**TOWN AND COUNTRY PLANNING ACT 1990
PLANNING CONSULTATION**

Erection of 6 dwellings off Town Dam Lane, Donington, Spalding PE11 4TR

I refer to the submitted planning application reference H04-0425-22. The Fire Authority objected to this planning application on the grounds of inadequate access and turning for a fire appliance to ensure the long-term fire safety of the residents. The objection is removed on the following basis:-

Drawing
SITE PLAN - PROPOSED
LOCATION PLAN

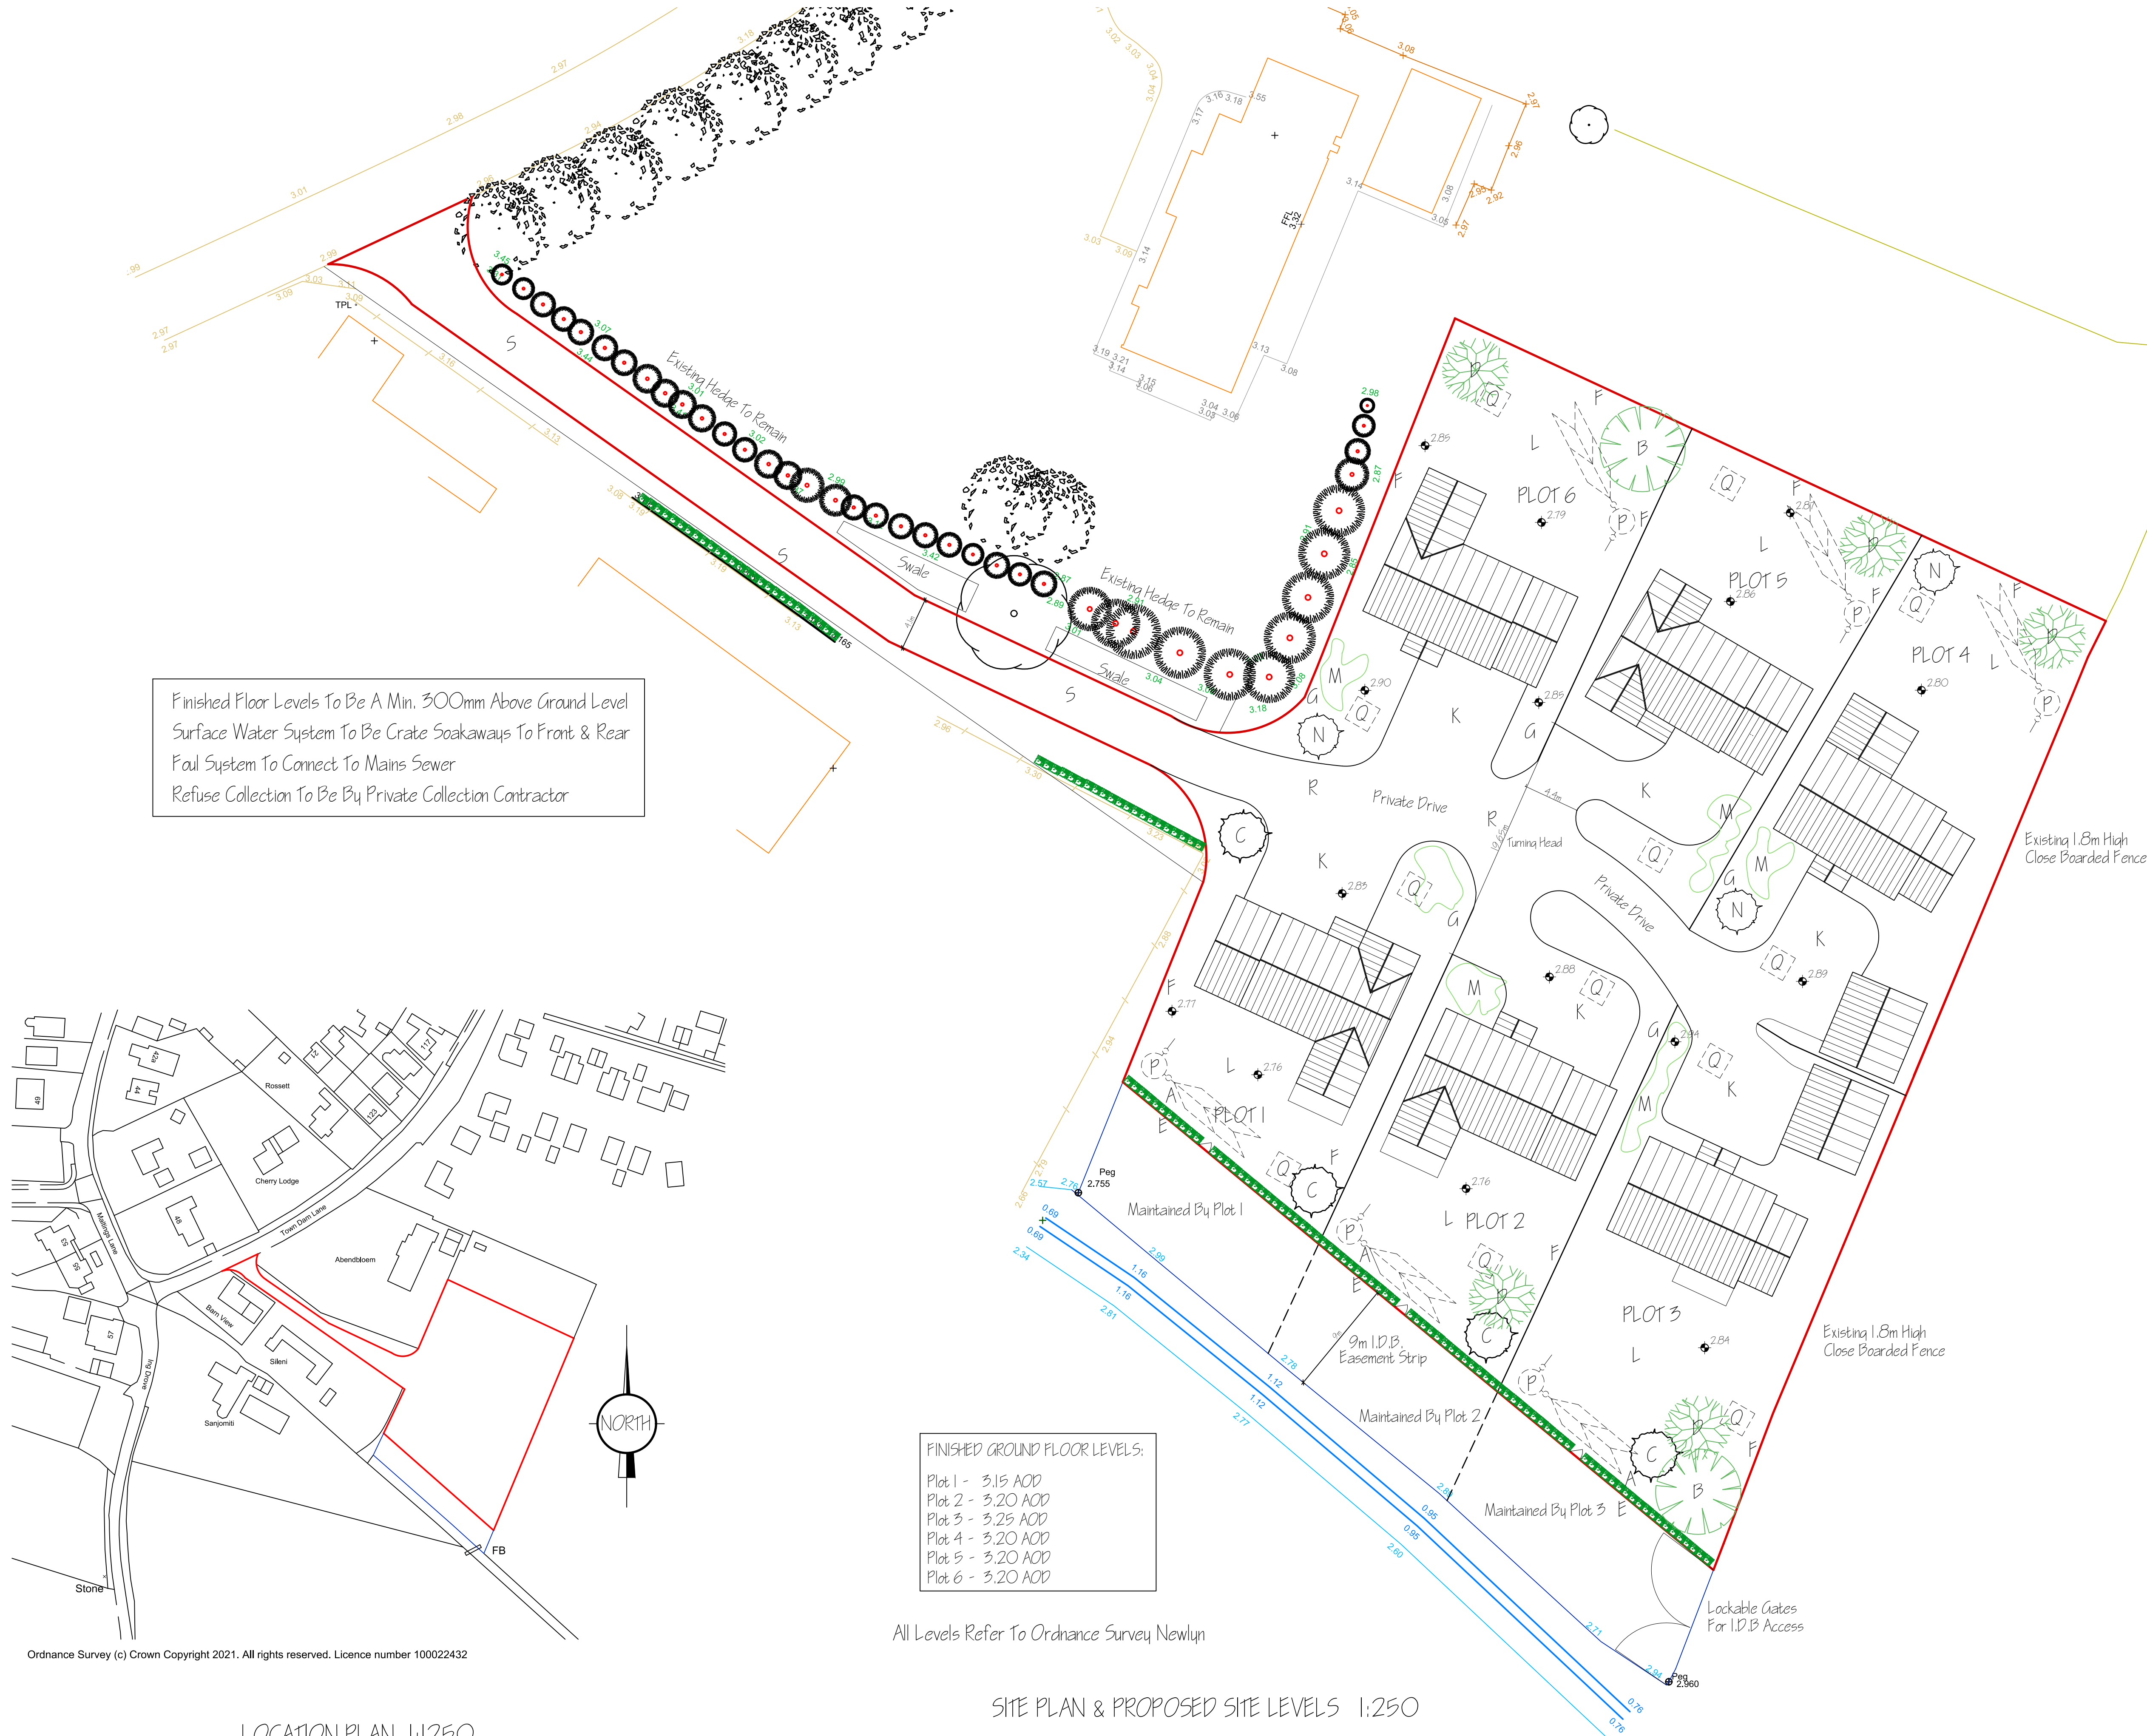
The site layout drawing has been amended by the developer to provide access to buildings for fire appliances and fire fighters as specified in the Building Regulations 2010 Part B5.

The vehicle access road and turning provision is a workable solution provided that the block paved access road surface construction gives a minimum carrying capacity for a Lincolnshire pumping appliance of 18 tonnes and not 12.5 tonnes as detailed in the Building Regulations 2010 part B5.
